Black Forest Meadows, VA-21-1

Please accept the following comments from El Paso County Public Health for the variance request referenced above:

Black Forest Meadows
Outdoor Wedding Venue
Concept Plan
April 7, 2021

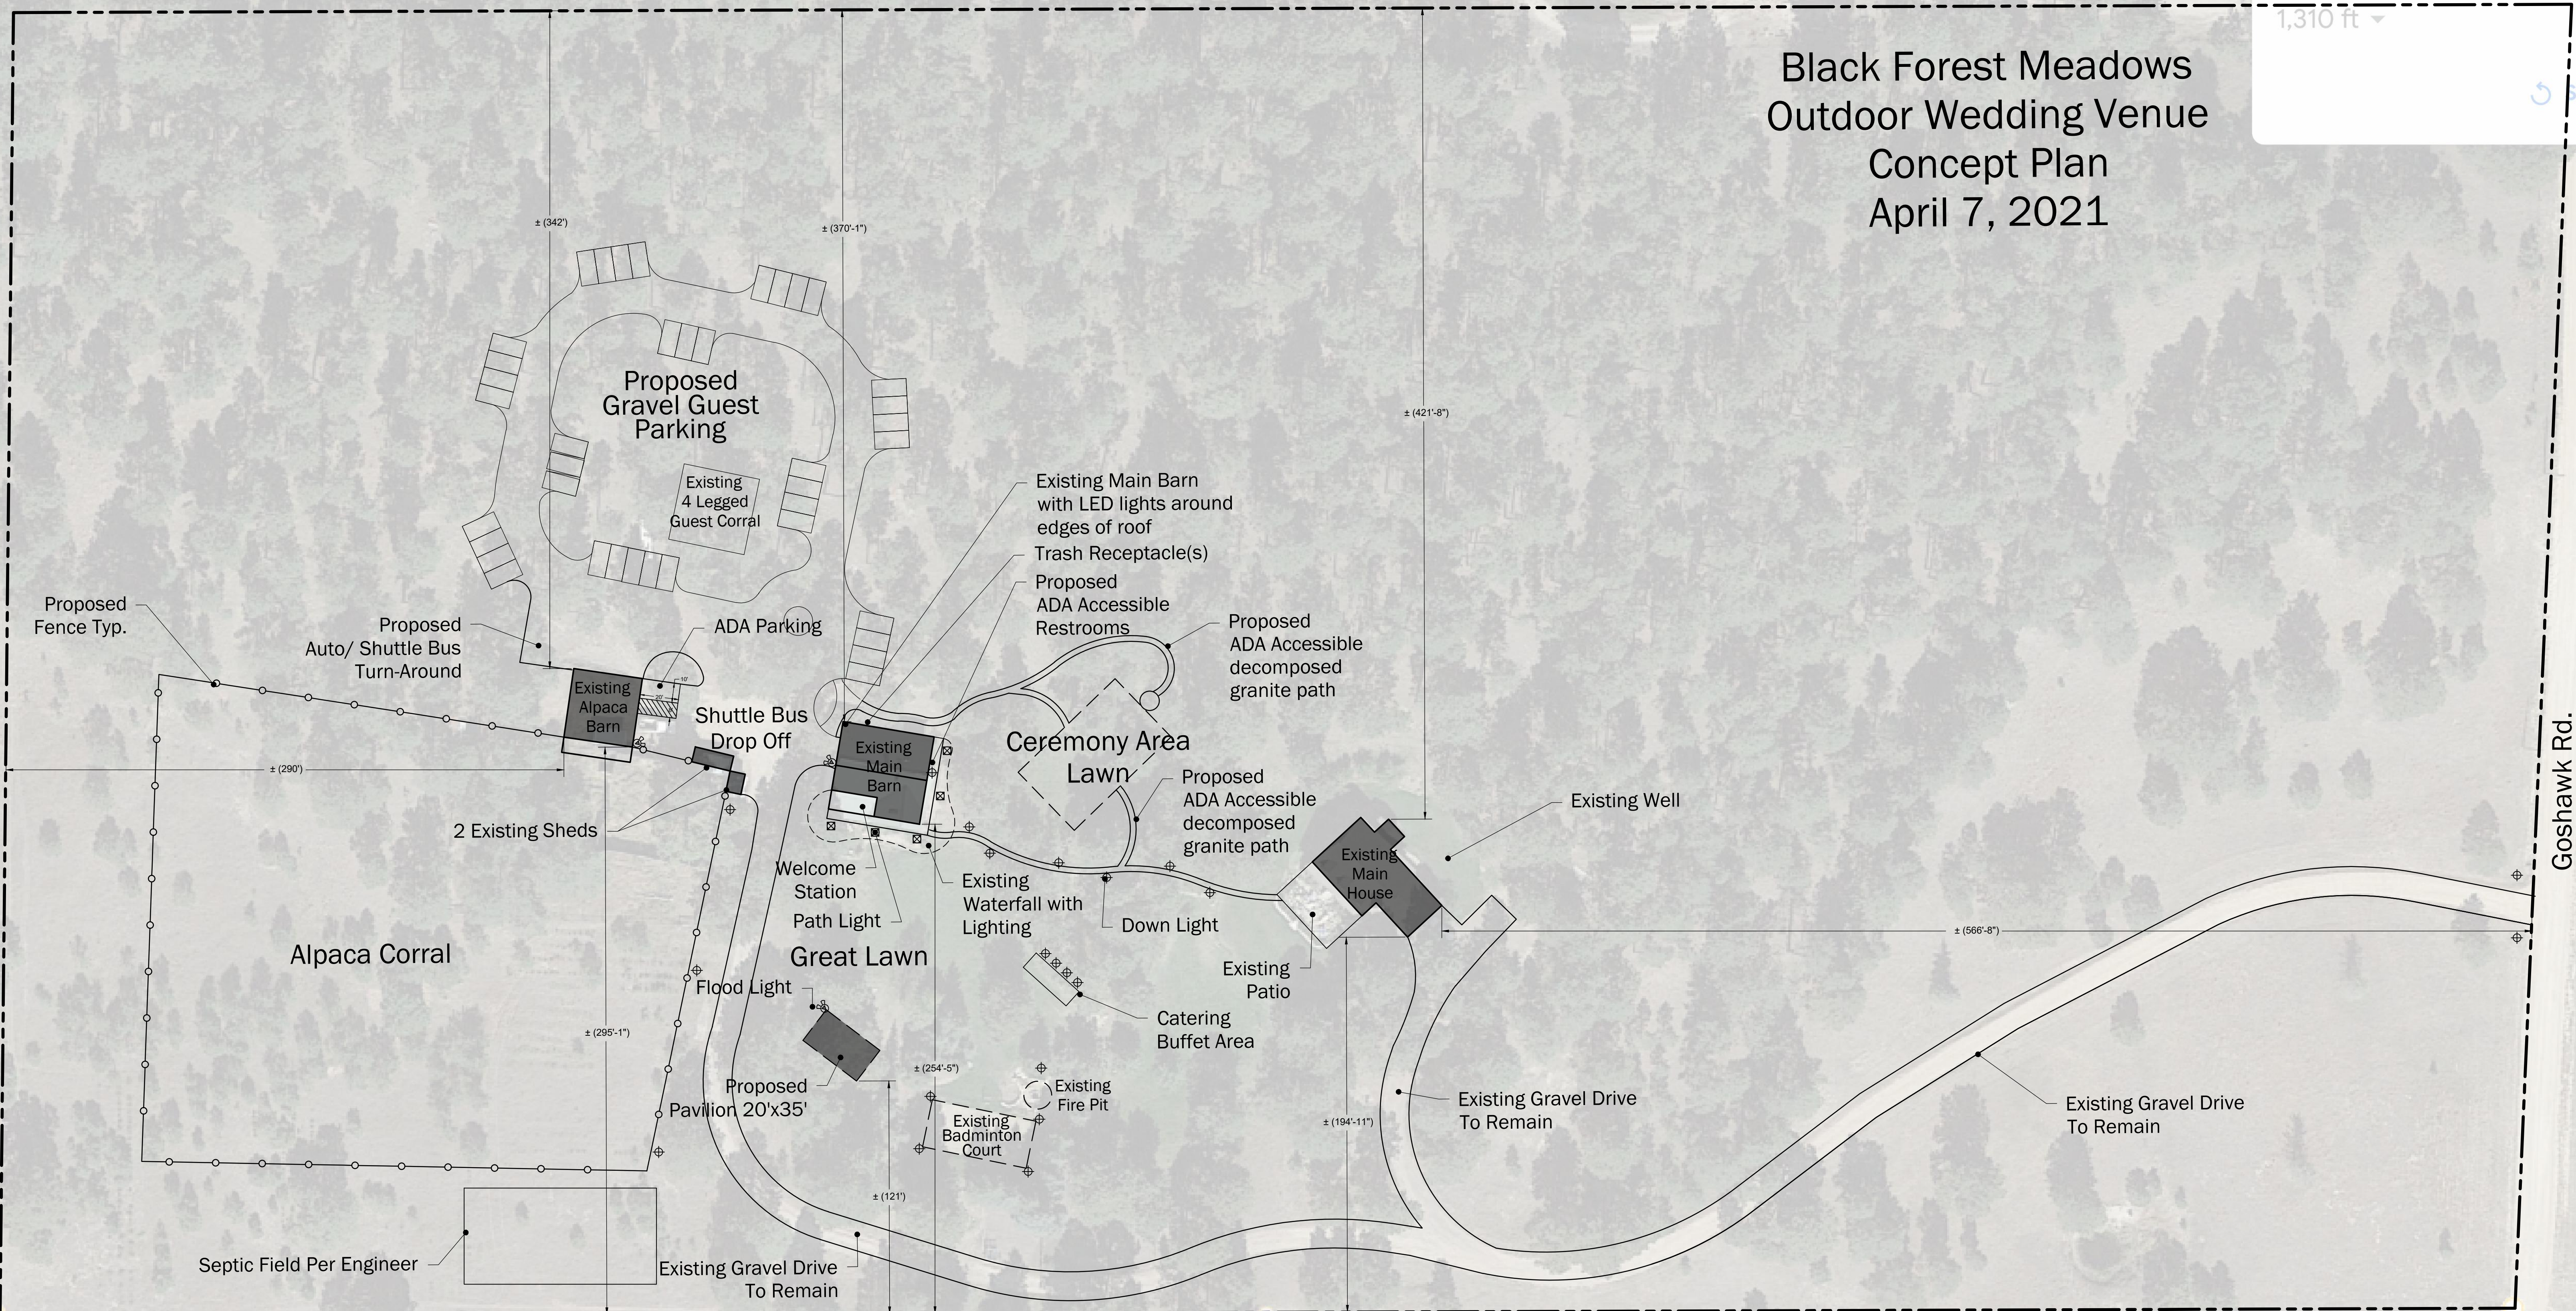
- **Wastewater service for the proposed event center is by a new onsite wastewater treatment system (OWTS) and was designed by JDM Consulting, LLC. The design includes the use of an existing OWTS septic tank with a new soil treatment area (STA). The new design flow calculations must include the flow from the existing structure it serves as well as the wastewater flow calculated for the proposed event center. The per person wastewater flow rate and calculations were not included with the submittal but will be required at the time the design is submitted for the OWTS Permit at El Paso County Public Health. was based upon flows for an Assembly Hall. Please be aware the alternate site for the new STA appears to be within the Alpaca Corral based upon the Site Plan Drawing submitted by the applicant.**

- **Please contact the El Paso County Health Department, Food Program, for information on the service of food/beverages and licensing, if necessary, at the site. Call 719-578-3199, option 3. Food service was not addressed in the Letter of Intent, but a Catering Buffet Area was included on the Site Plan.**
